Your Ref: OWPC17355
Our Ref: FG/1/18/HH 05-01-2018
Please ask for:
Ross Leal

Loft conversion & rear extension
63 Midhurst Drive Ferring

Thank you for your internet representation made on 12th February 2018 which has been recorded as '**an objection**' with the comments as follows:

DRW NO 4 SCALE 1/50 (A3)
PROPOSED ROOF PLAN

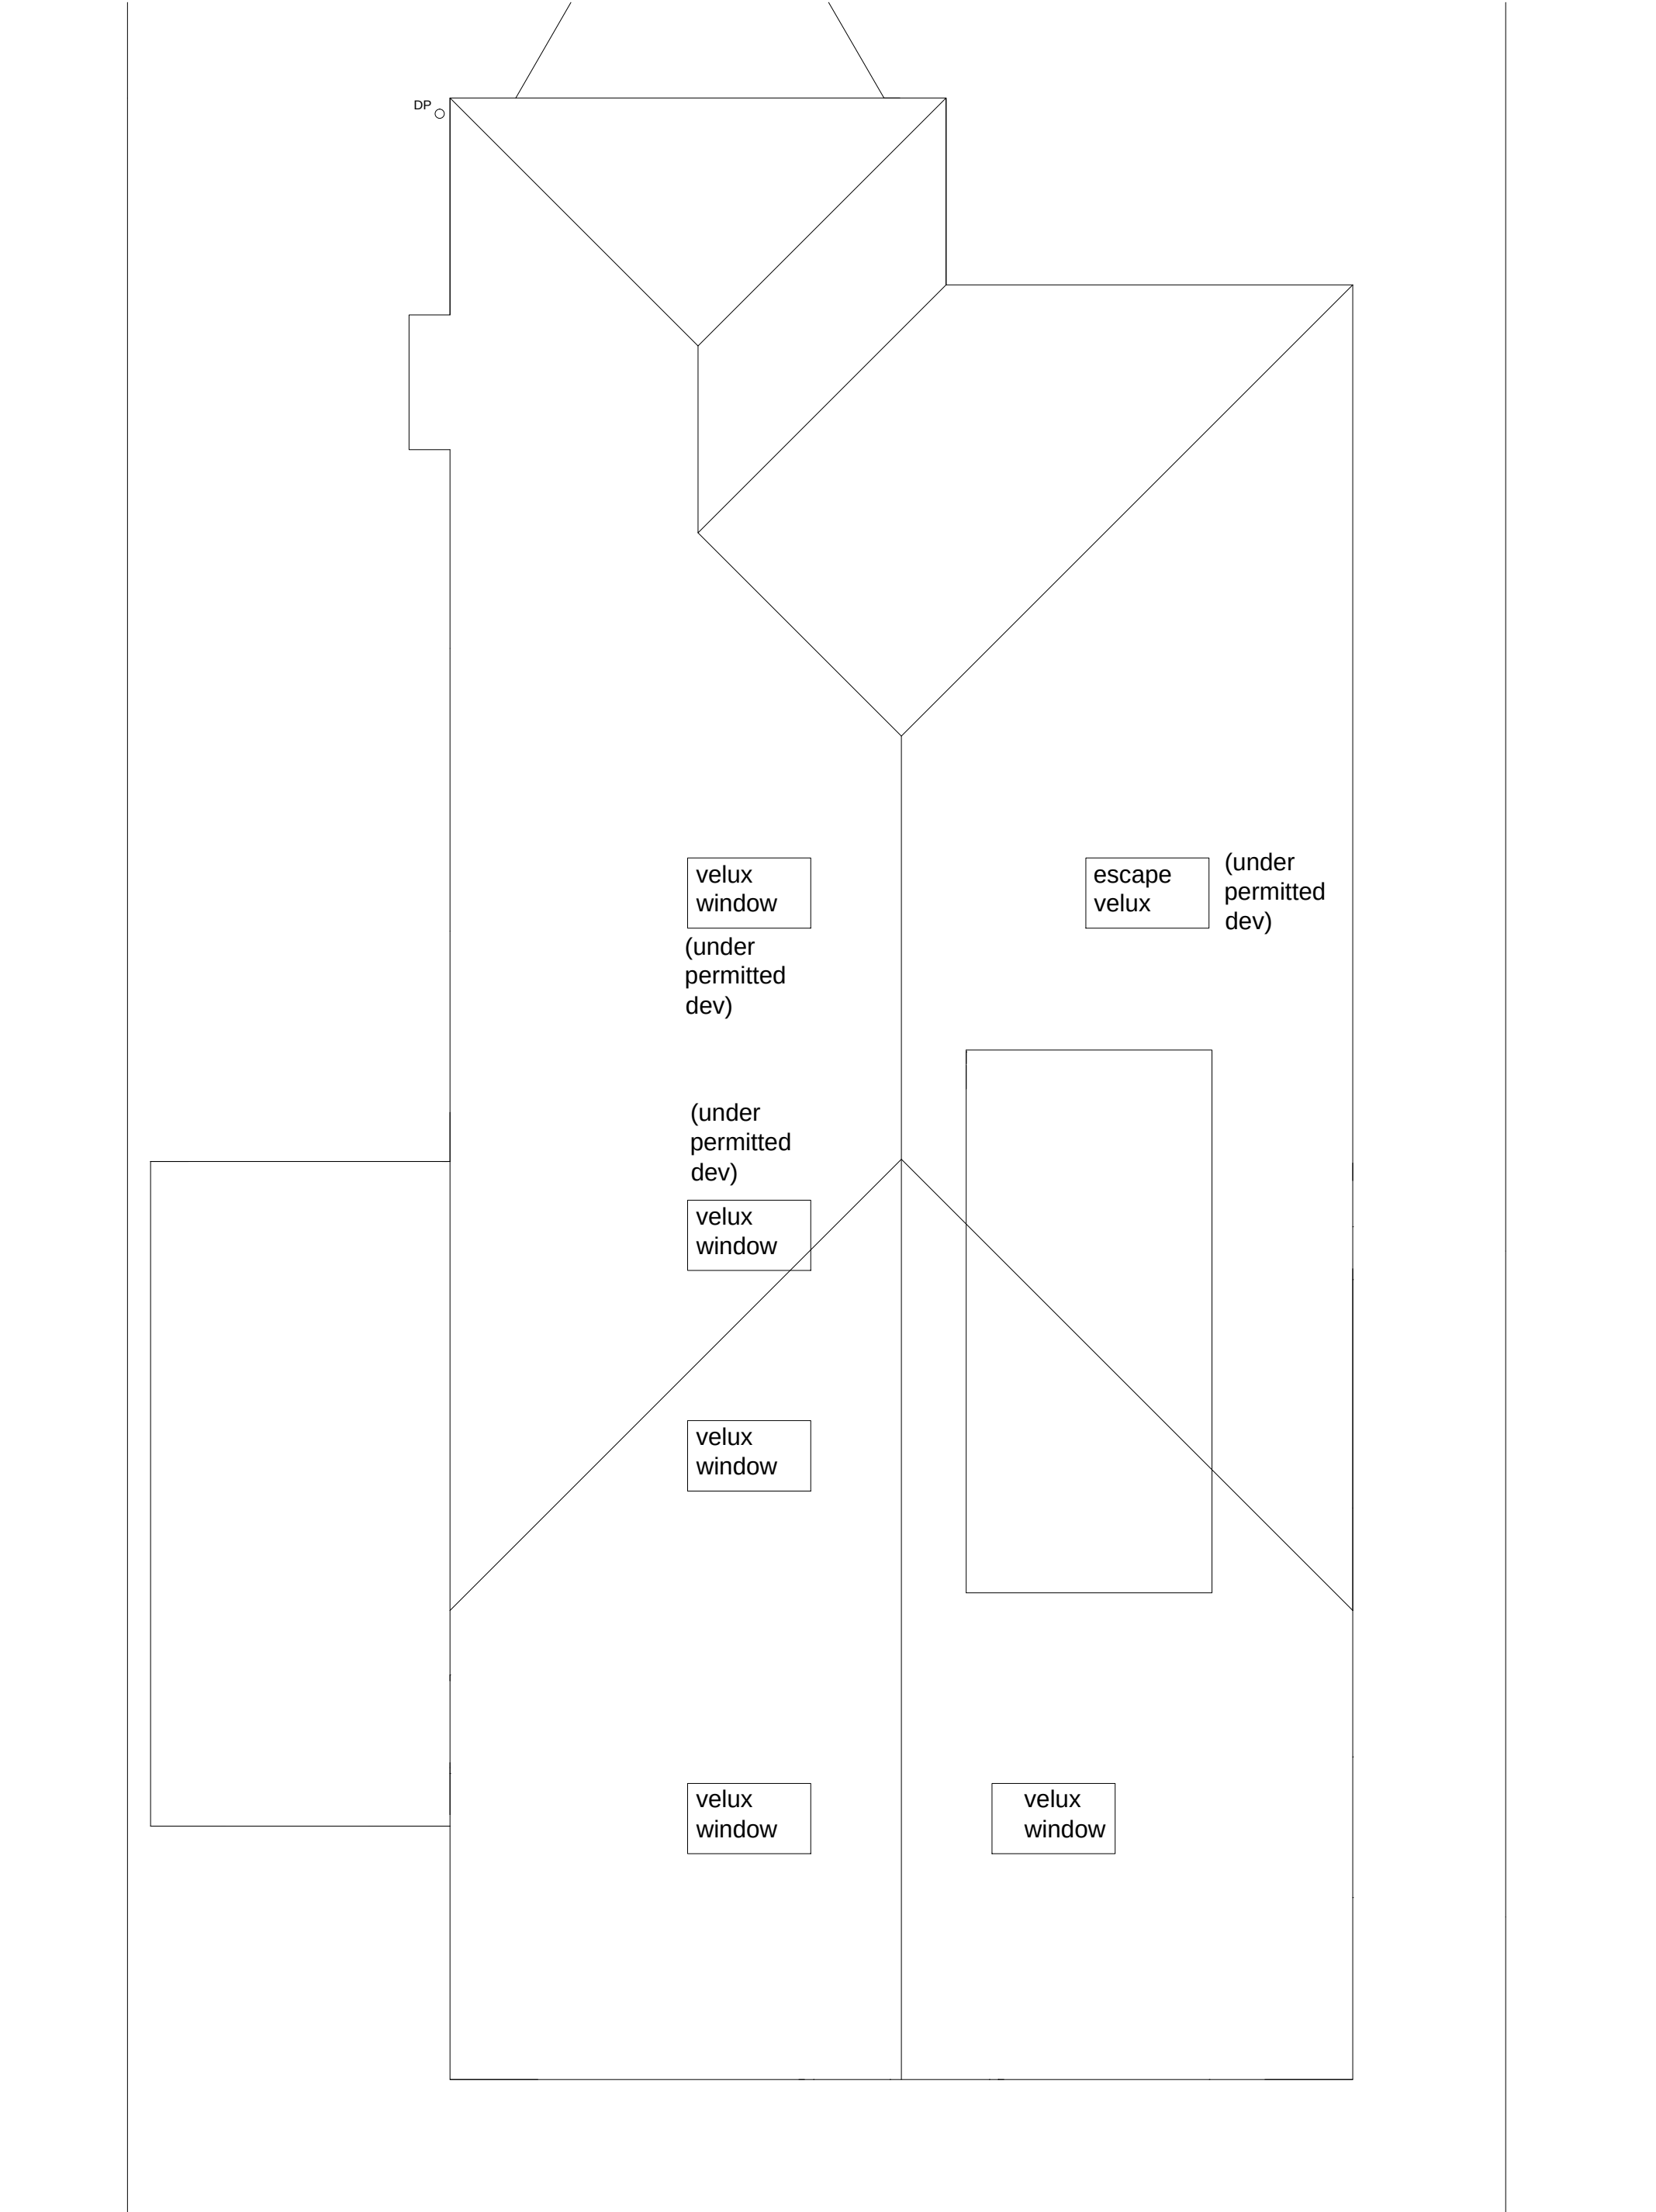
We believe that the proposed extension, with its gable end and "Juliet" balcony impinges on the Ilex Avenue by its bulk and height to the detriment of this local amenity and to the enjoyment of the users of the Avenue.

Although replacement of the gable end with a suitably hipped end and possible rooflight may alleviate the harm to the Avenue to some extent, we would strongly urge the Council to reject this application as currently proposed.
